RE: SITE PLAN – ADMINISTRATIVE DEVELOPMENT FACILITATION TEAM TRACT 52-A, UNIT 2 TRACTS ALLOTTED FROM TOWN OF ATRISCO GRANT PR-2018-001681 SUNSET GARDENS

Development Facilitation Team (DFT) – Review Comments

Project No: PR-2018-001681 Date: 03/06/2024 Agenda Item: #1 Zone Atlas Page: MX-L

Application For: SI-2024-00271 – SITE PLAN DFT

DESIGNED	PROJECT NO
DRAWN	SCALE
CHECKED	DRAWING NO
REVIEWED	A-100
DATE 11/28/2023	OF

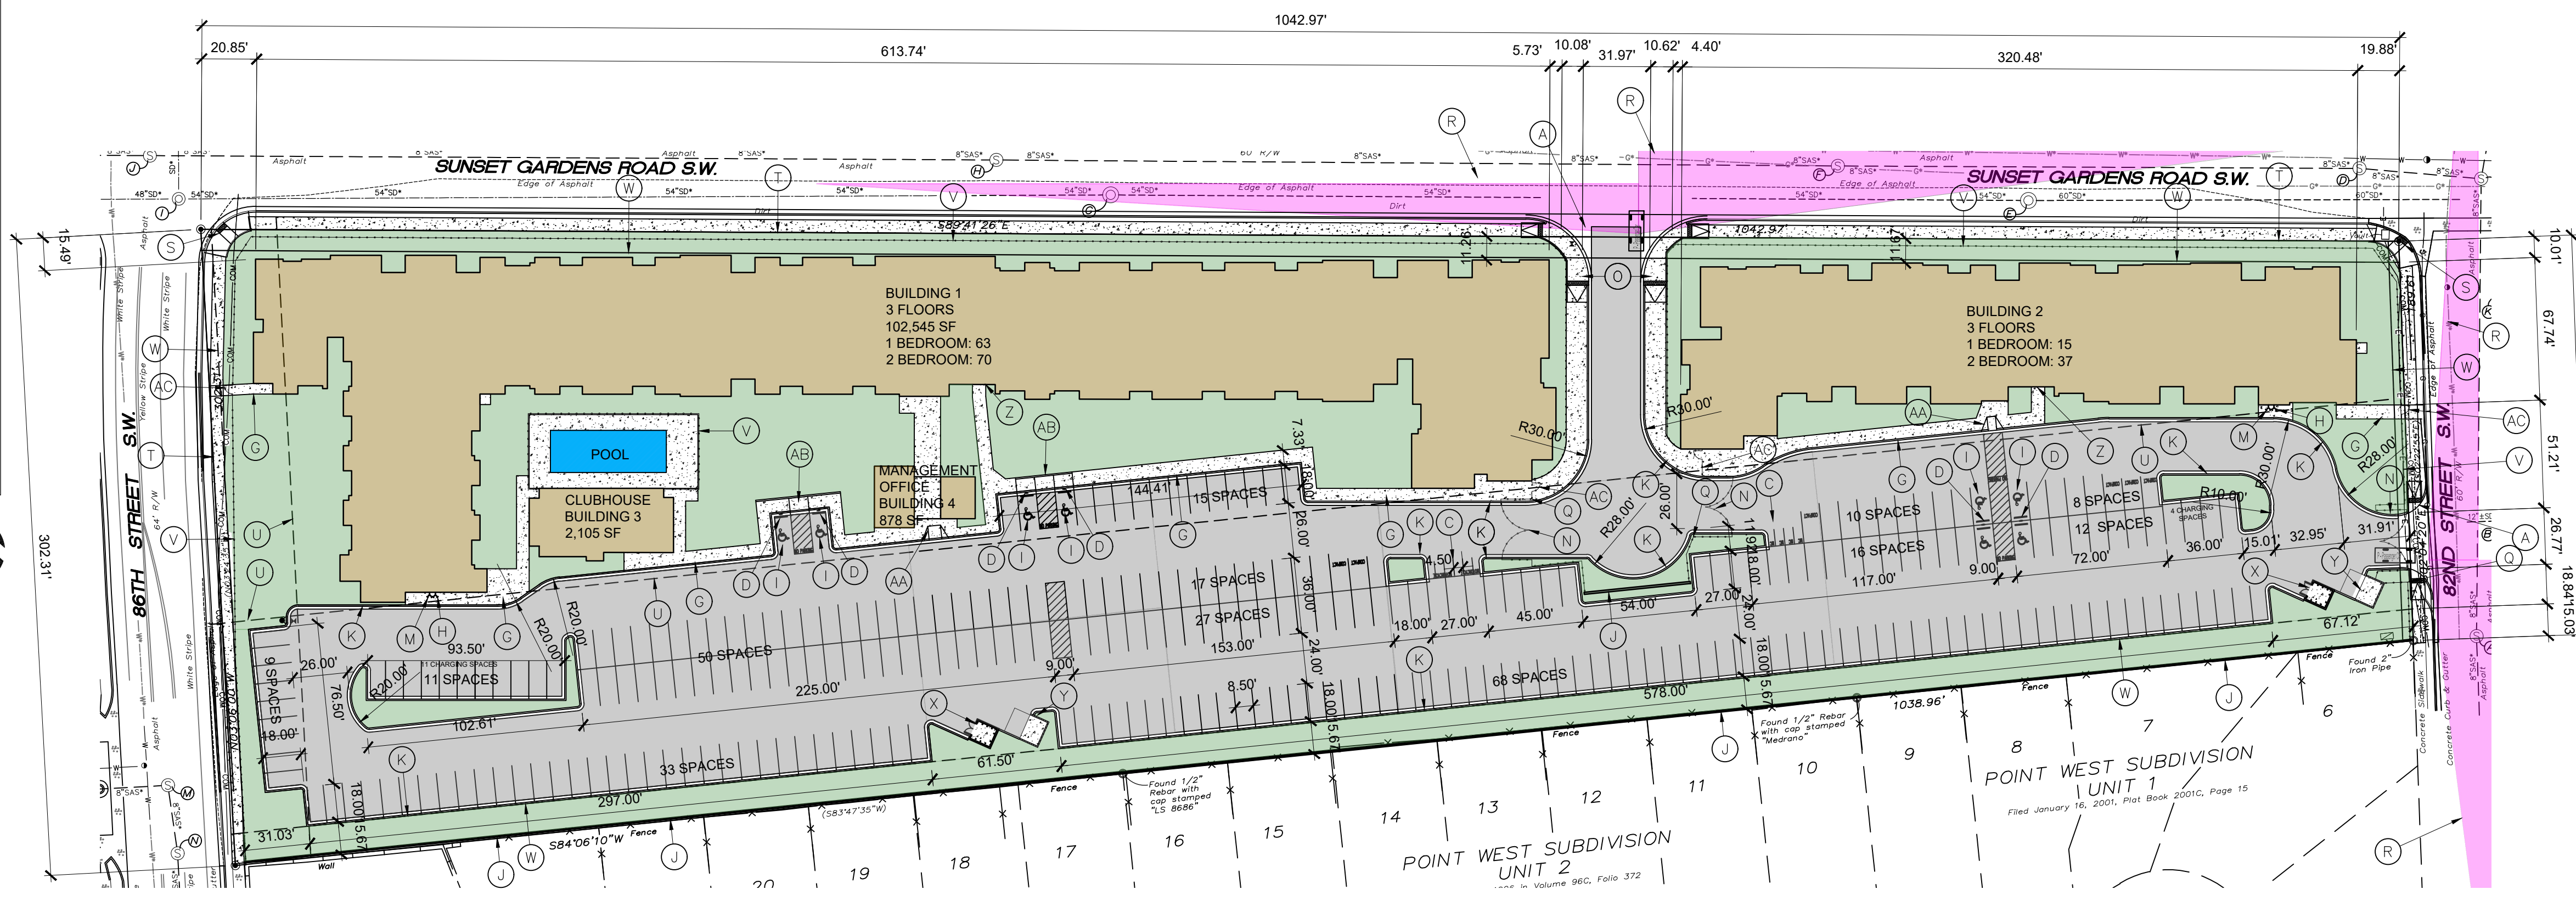
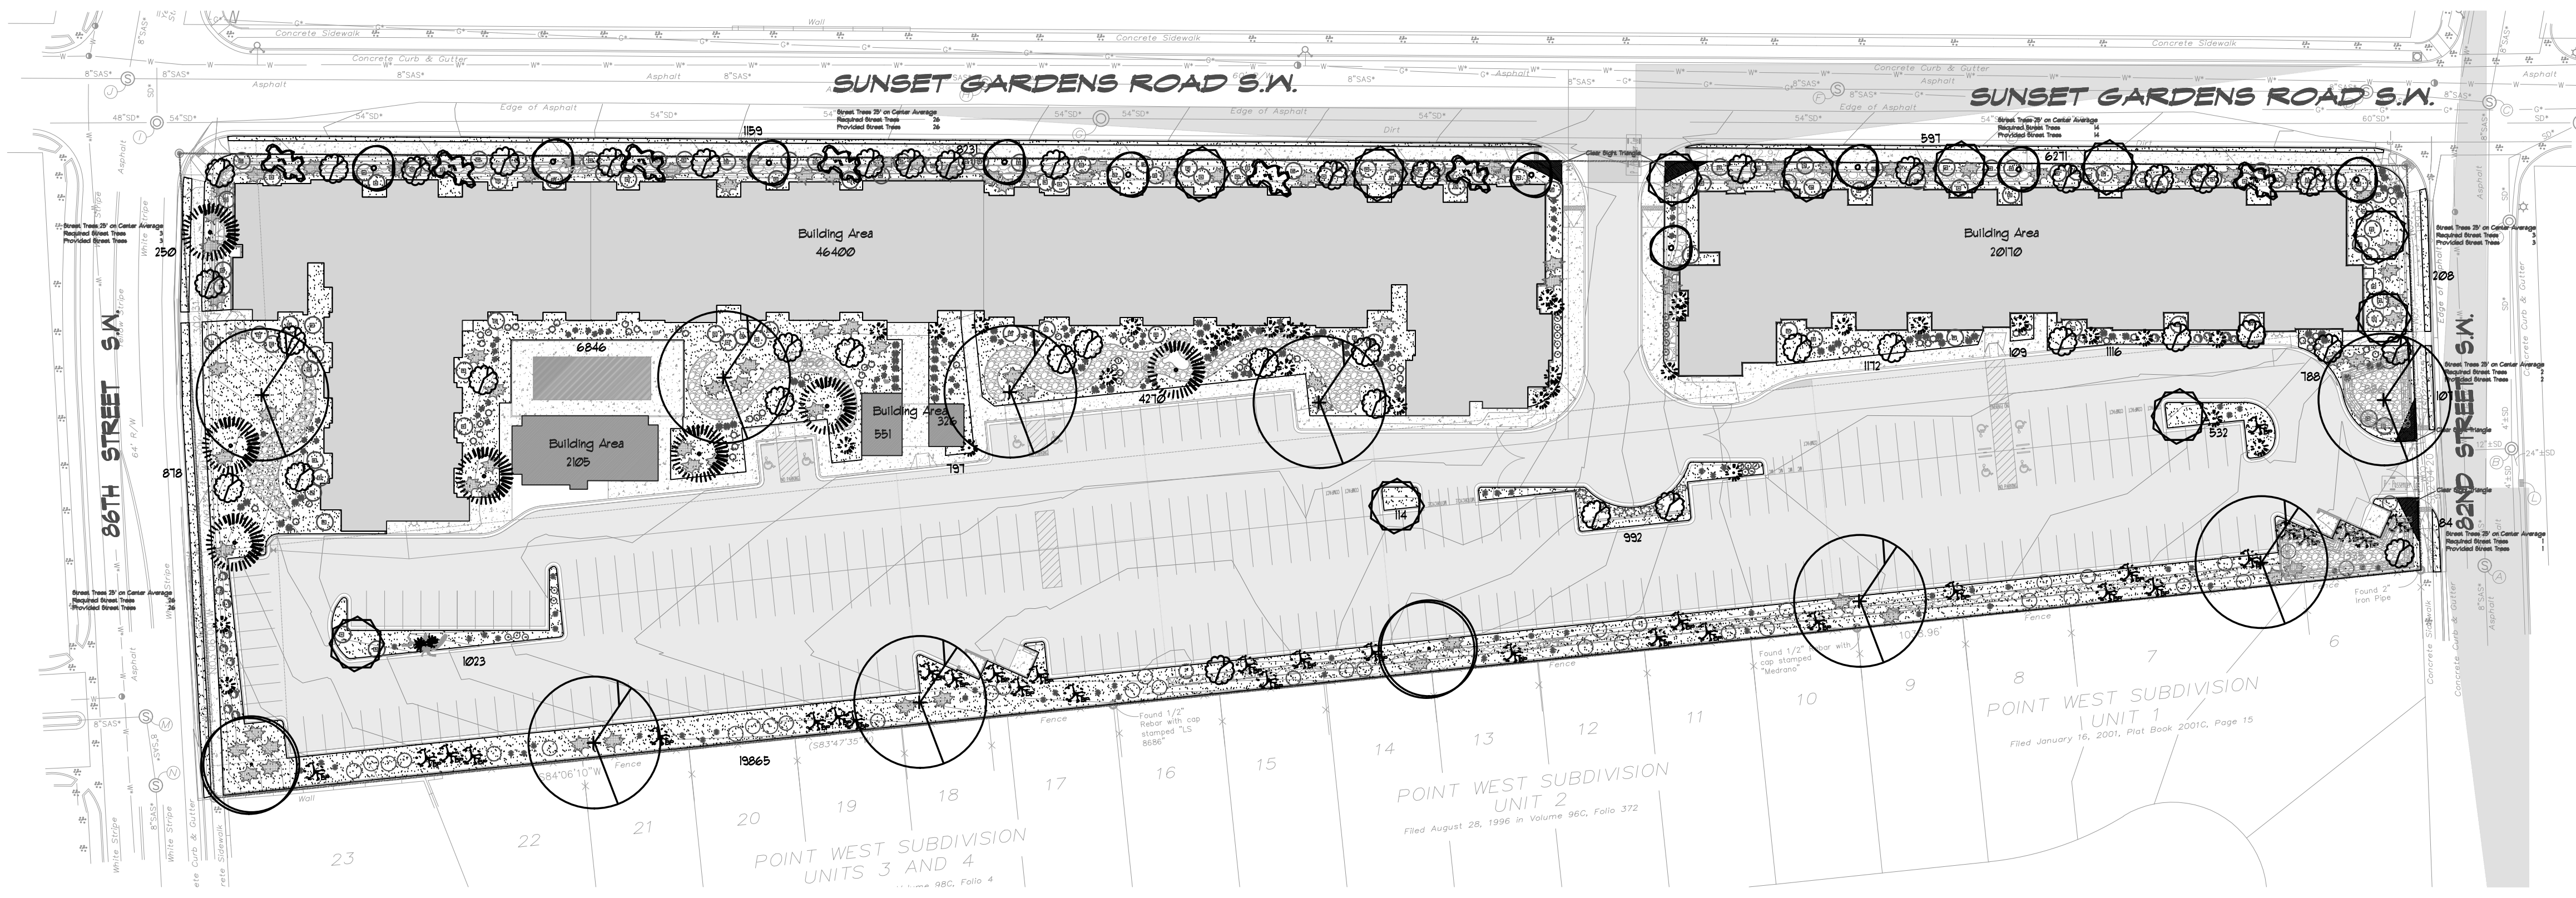
6. The average width of the walkway along the entire length of the façade is a minimum of 8 feet 14-16-5-3(D)(3)(b)(4).

-Front Minimum setback: 5 ft. Planning identified two lot fronts in the north and east edge of the property. Planning defers to Code Enforcement for confirmation.

RESPONSE: See updated sheet A-100 the average walway along the façade on average is 8 ft including sidewalk and curb width.

RESPONSE: See dimensions sheet A-100.

ENGINEER'S SEAL	SUNSET APARTMENTS ALBUQUERQUE, NM	DRAWN BY RMG
	MASTER UTILITY PLAN	DATE 05-15-2023
RONALD R. BOHANNAN P.E. #7868	TIERRA WEST, LLC 5571 MIDWAY PARK PL NE ALBUQUERQUE, NEW MEXICO 87109 (505) 858-3100 www.tierrawestllc.com	SHEET # C3.0
		JOB # 2022028

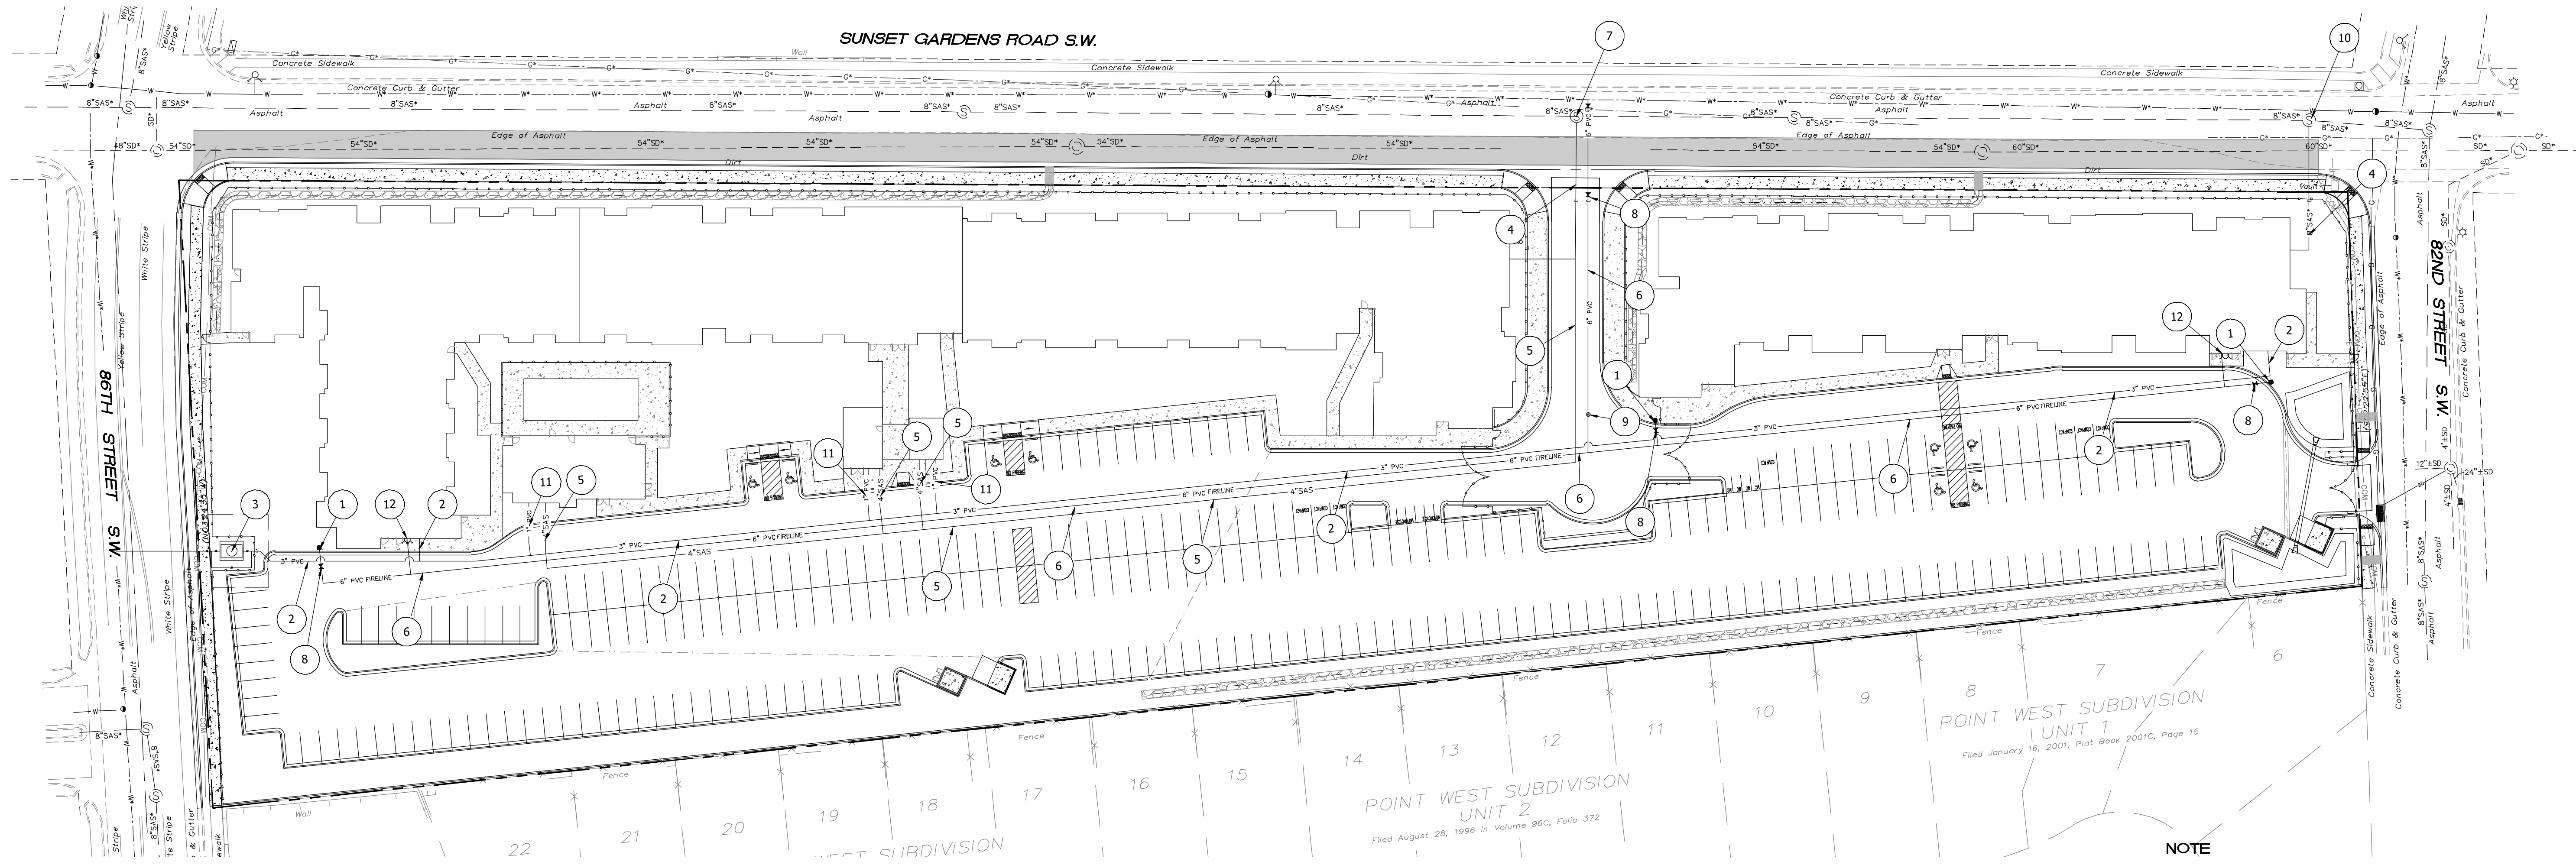
2. Please label the fire hydrants on-site as private and to be painted safety orange.

RESPONSE: Refer keynote #1 on the master utility plan sheet C3.0.
